## MEMORANDUM

**TO:** Jean Fraser, Planner  
**FROM:** David Senus, P.E.  
**DATE:** March 17, 2016  
**RE:** 1363 Washington Ave, Final Level II Site Plan Application & Response to Comments

Woodard & Curran has reviewed the response to comments submittal and the Final Level II Site Plan Application for the proposed Taco Bell restaurant located at 1363 Washington Avenue in Portland, Maine. The project involves the redevelopment of an existing restaurant site into a Taco Bell restaurant.

Not Approved for Construction
Drawing Title
Layout & Materials

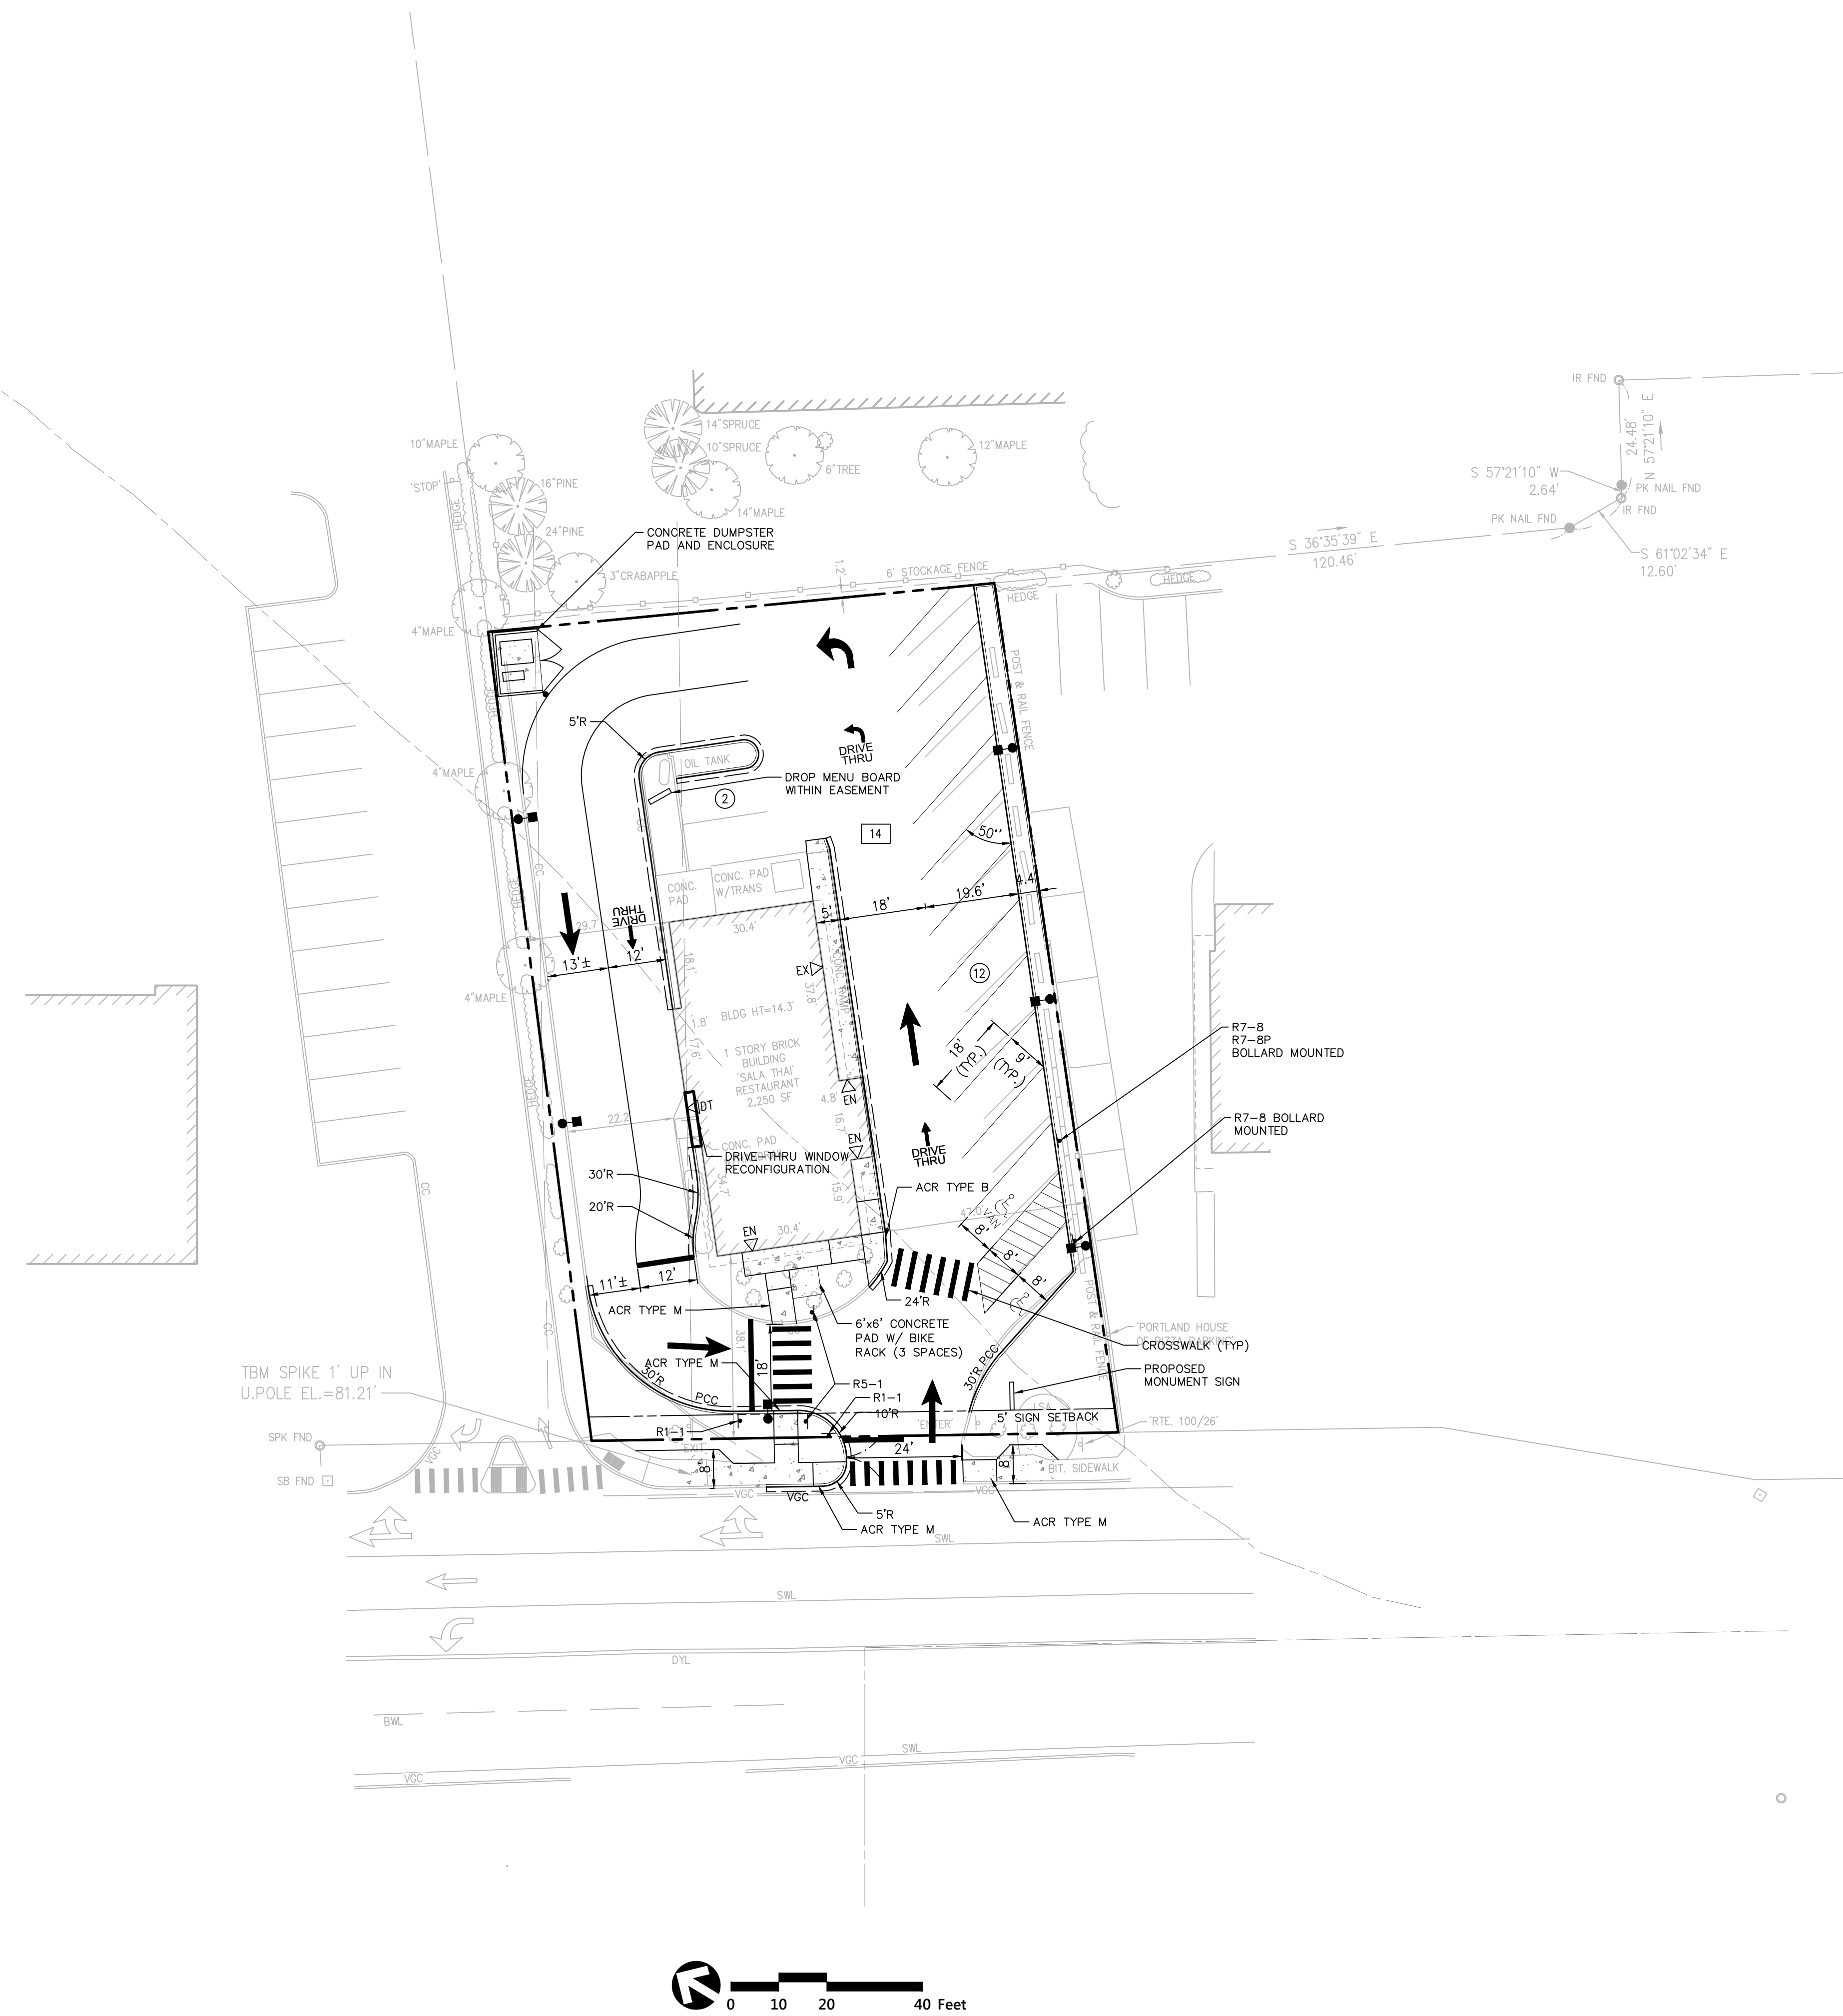
- 1) The plans should include notes and details related to best practices for erosion and sediment control associated with the site disturbance for installation of the sidewalk, revised curb layout and grease trap. This should include, at minimum, inlet protection for any adjacent catch basins (silt-sacks) and frequent street sweeping of the parking area and adjacent roadway. The plans should also include notes related to good housekeeping practices and pollution prevention during construction.

DATE: AUGUST 2009  
 REVISIONS: N.T.S.  
 CITY OF PORTLAND, MAINE  
 TECHNICAL STANDARDS MANUAL  
 TRANSPORTATION SYSTEMS AND STREET DESIGN  
 SECTION I  
**REINFORCED CONCRETE SIDEWALK**  
 FIGURE: I-14  
 SOURCE: VHB  
 LD\_552

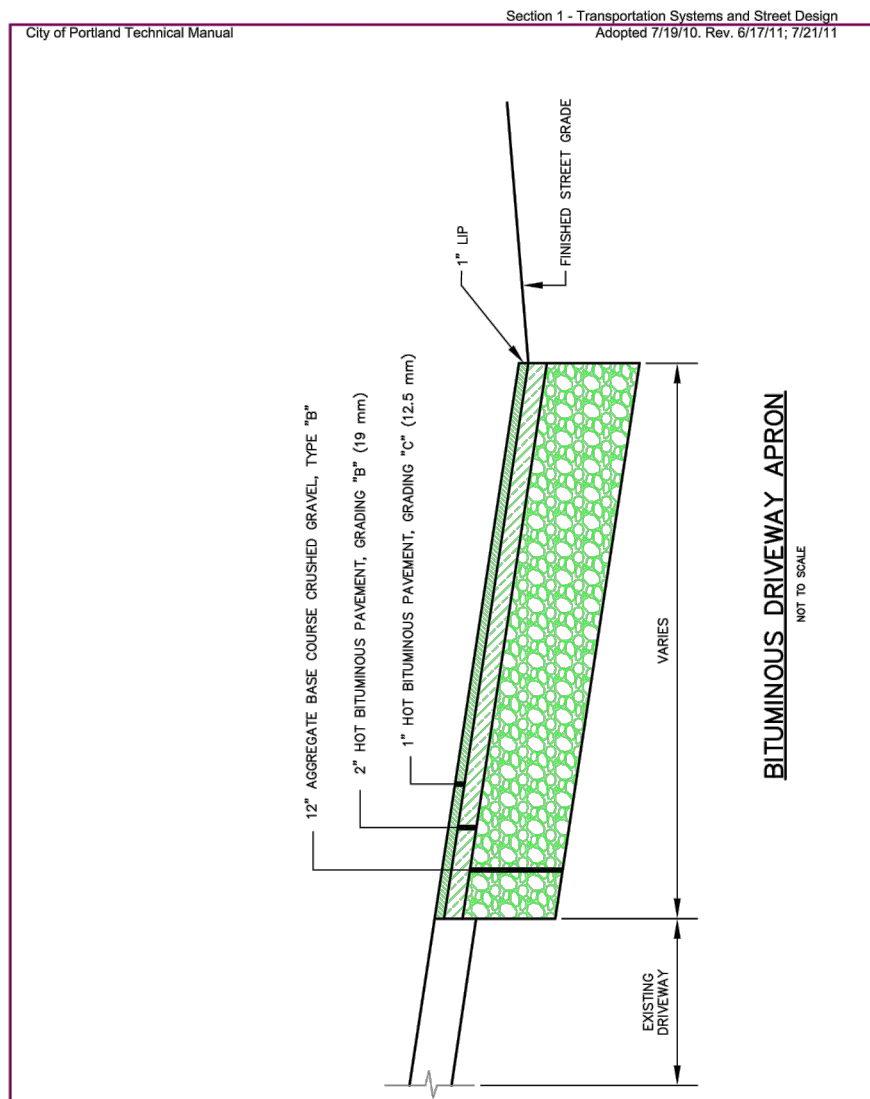
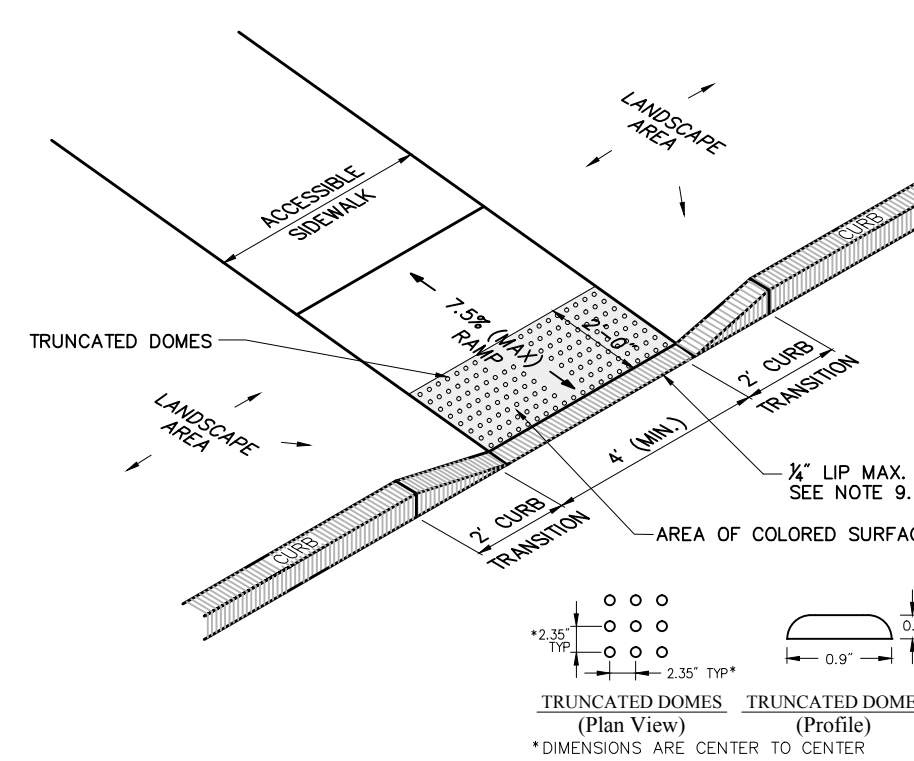
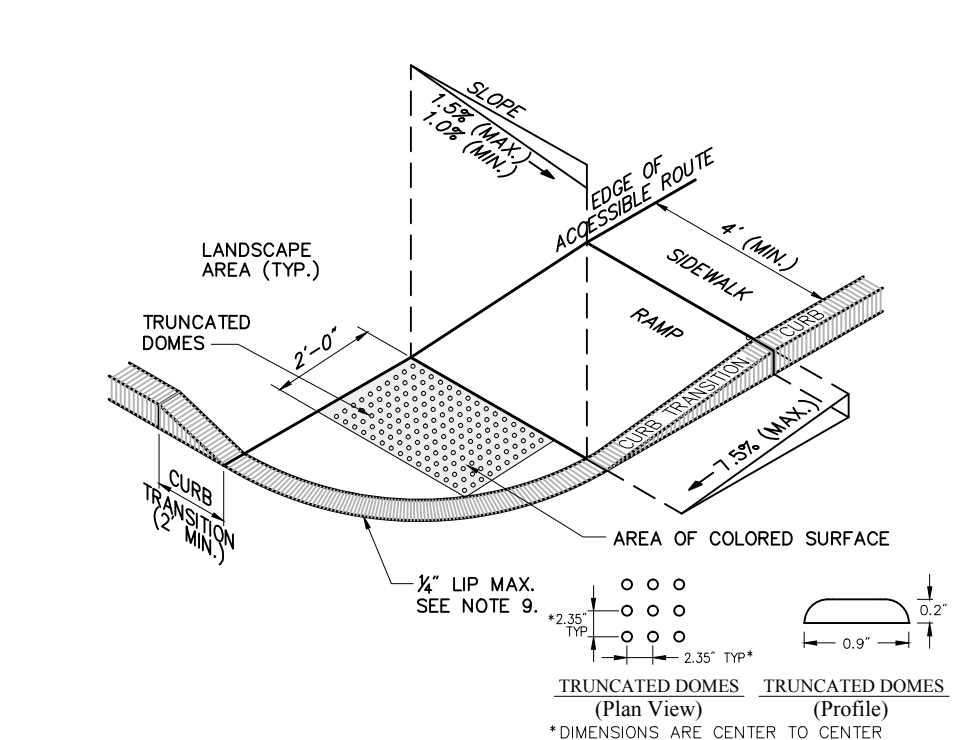
- 2) No detail sheets were provided with the resubmitted plans. Details associated with work proposed within the City Right-of-Way should be revised to comply with the City of Portland Technical Manual; these details include:

- a) concrete sidewalk;
  - b) granite curbing;
  - c) pavement repair in the ROW
- 3) The Applicant has noted that they await a letter from the Portland Water District confirming capacity to serve the water demand for the new restaurant.
